16 May 2022
L 220516 NS RB Covering letter and Addendum Planning Statement FINAL

Section 73 Town and Country Planning Act 1990
Application to Vary Conditions 2 and 4 and Remove Condition 8 of Full Planning Permission Ref. 21/02366/F relating to land at Wincote, Cow Lane, Steeple Aston, OX25 4SG
On behalf of Mr. Henry Squire
Planning Portal Reference: PP-11254666

ADDENDUM PLANNING STATEMENT

Drawing Number	Revision
20064-SQP-ZZ-ZZ-DR-A-PL220	P3

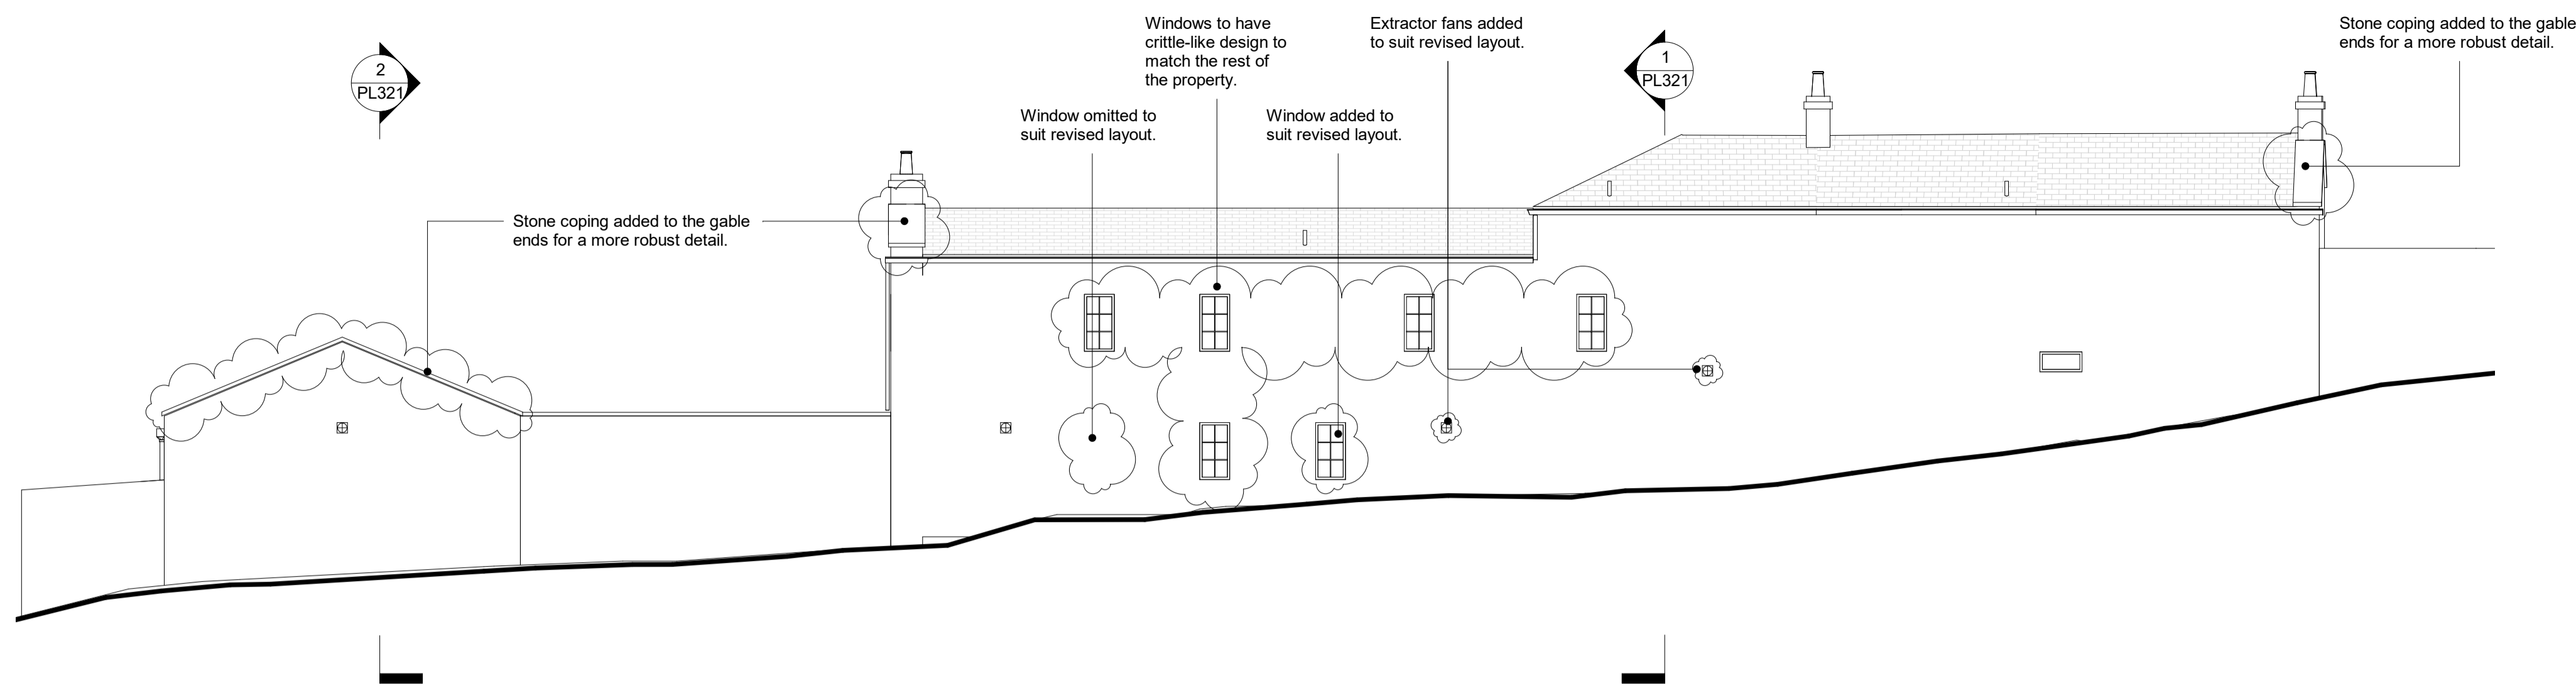
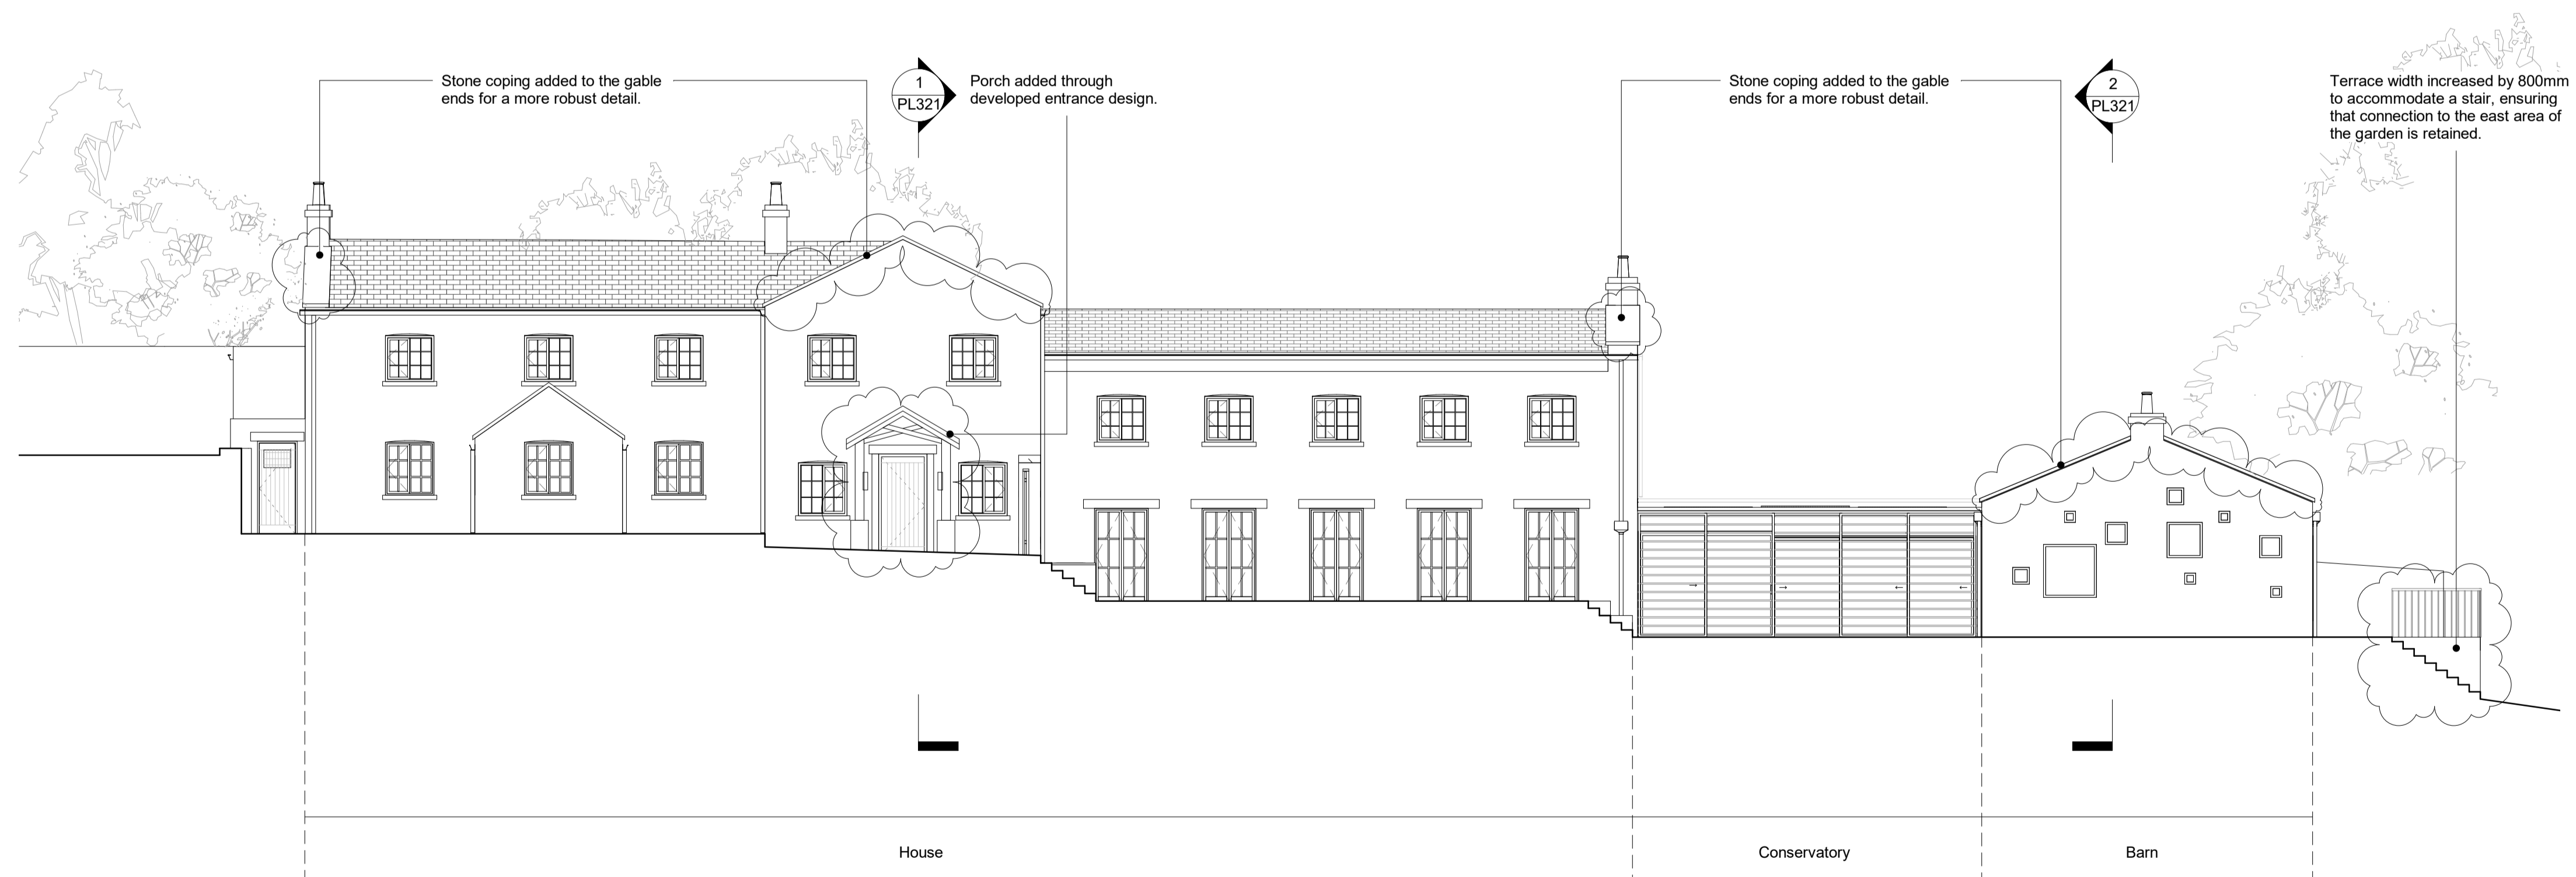
- Porch added to the entrance as part of design development.
- Stone copings added to the gable ends to create a more robust detail.

- Ground floor bathroom in the west wing has split into a shower room and en-suite for a more effective use of the space.
- Extractor fan added to the north façade of the utility room as required under the building regulations.

- Entrance hall WC moved to under the stairs to improve entrance accessibility and efficiency of the space. Window on north façade of snug has moved to suit the revised layout.

- Windows to the north and east facades to match style of the rest of the property.
- Bedroom windows above the entrance hall have been moved to sit centrally to the bedroom, windows at ground have also moved to maintain the alignment.

- 20064-SQP-ZZ-00-DR-A-PL122 - P4
- 20064-SQP-ZZ-01-DR-A-PL123 - P3
- 20064-SQP-ZZ-RF-DR-A-PL124 - P3
- 20064-SQP-ZZ-ZZ-DR-A-PL220 - P3
- 20064-SQP-ZZ-ZZ-DR-A-PL221 - P3
- 20064-SQP-ZZ-ZZ-DR-A-PL320 - P3
- 20064-SQP-ZZ-ZZ-DR-A-PL321 - P2

Drawn	Date	Scale @ ISO A1	Job Number
DOL	21/06/21	1:100	20064
Drawing Number	Revision		
20064-SQP-ZZ-ZZ-DR-A-PL221	P3

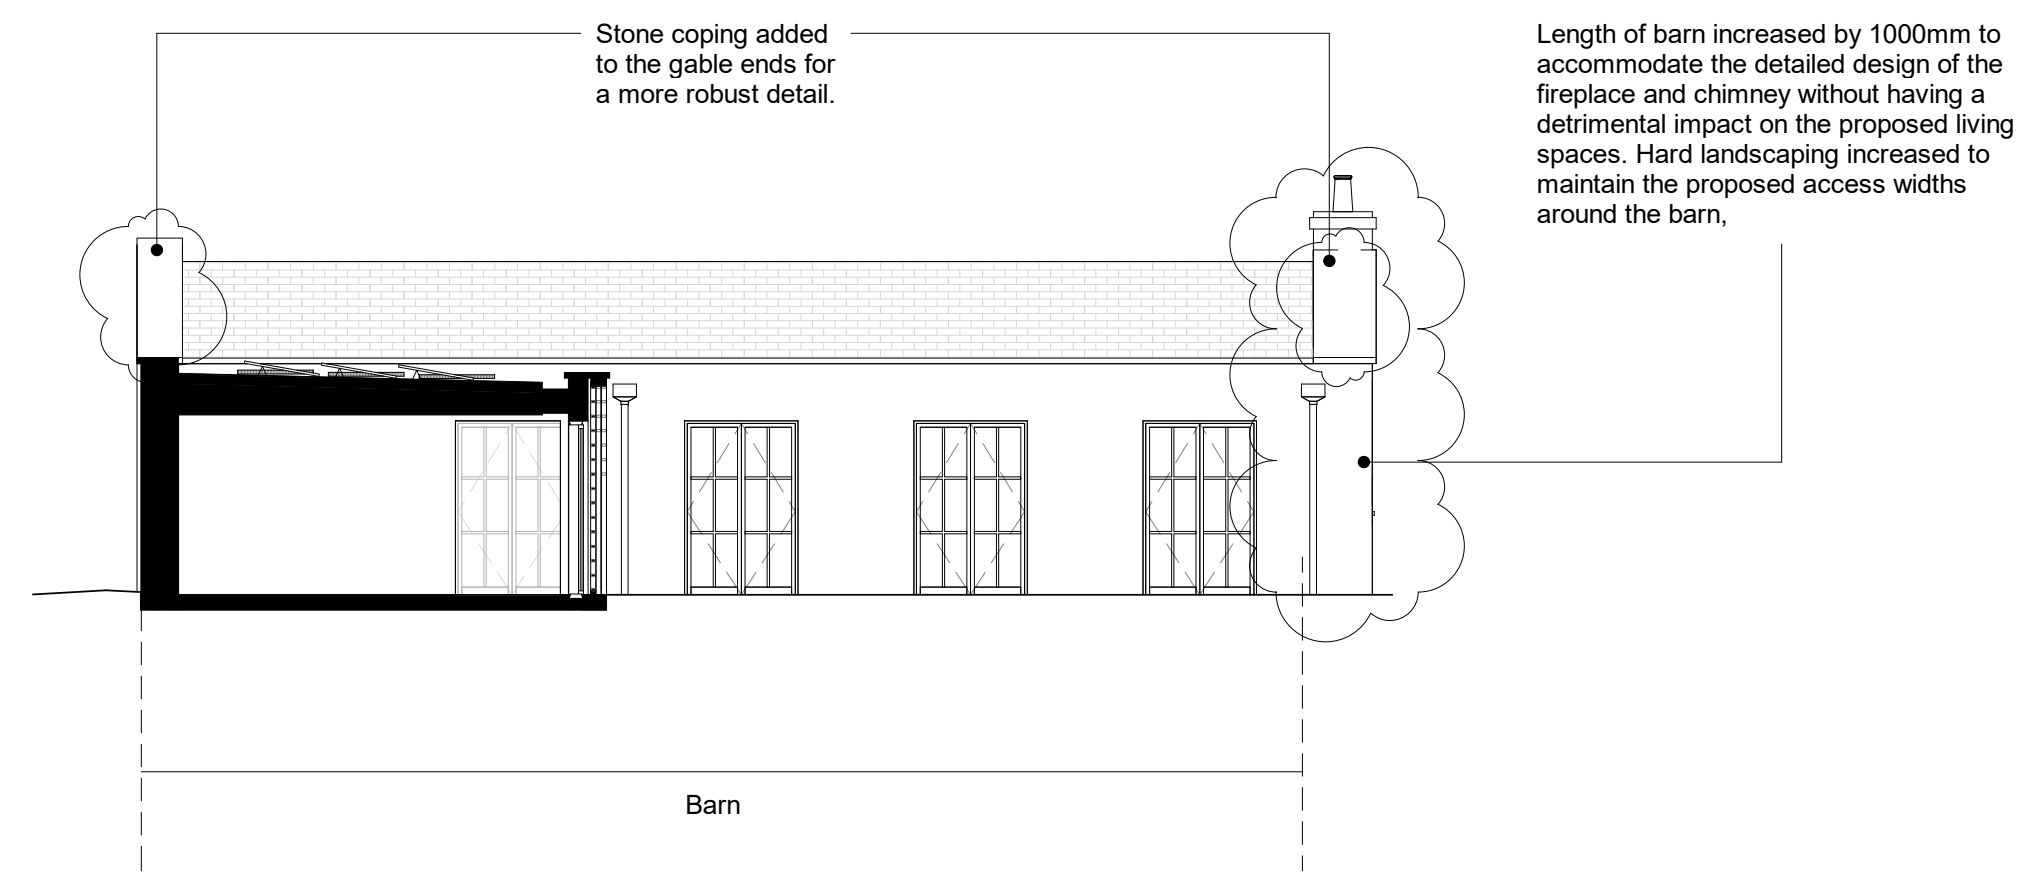
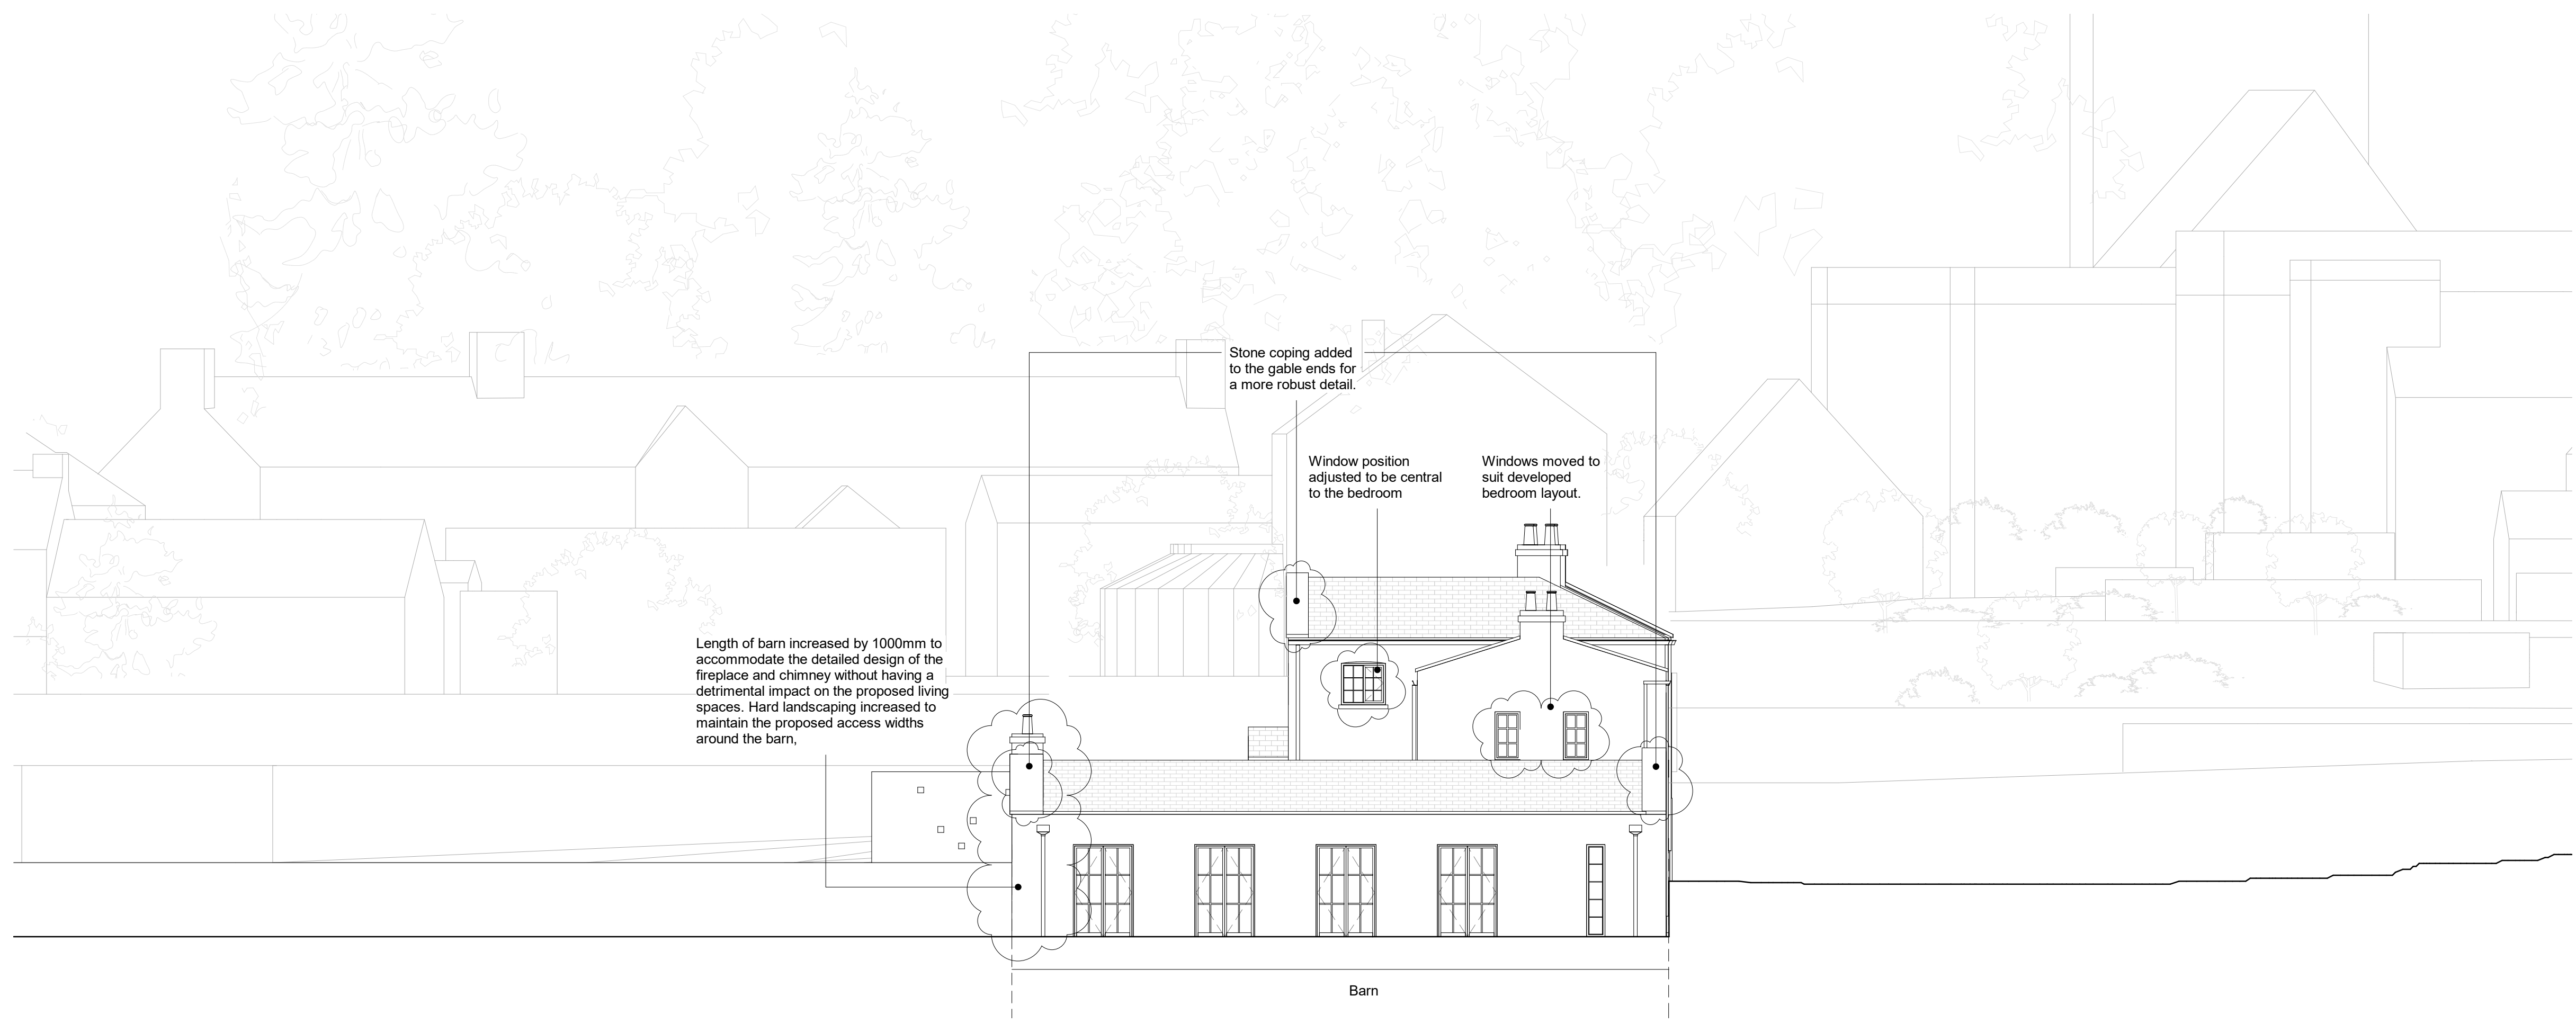
- Barn increased in length by 1m to accommodate the detailed design of the fireplace and chimney without having a detrimental impact on the consented living spaces.

- Width of the barn terrace has increased by 800mm to accommodate a stair, ensuring that connection to the east area of the garden is retained.
- Layout of spaces along the east wing ground floor corridor have been revised to provide increased storage, better connectivity to the first floor master bedroom and a more usable living space.

- Windows of the ground floor en-suite have enlarged for improved natural light into the space.
- Windows on the east façade of the master bedroom have shifted positions to better suit the developed bedroom layout.
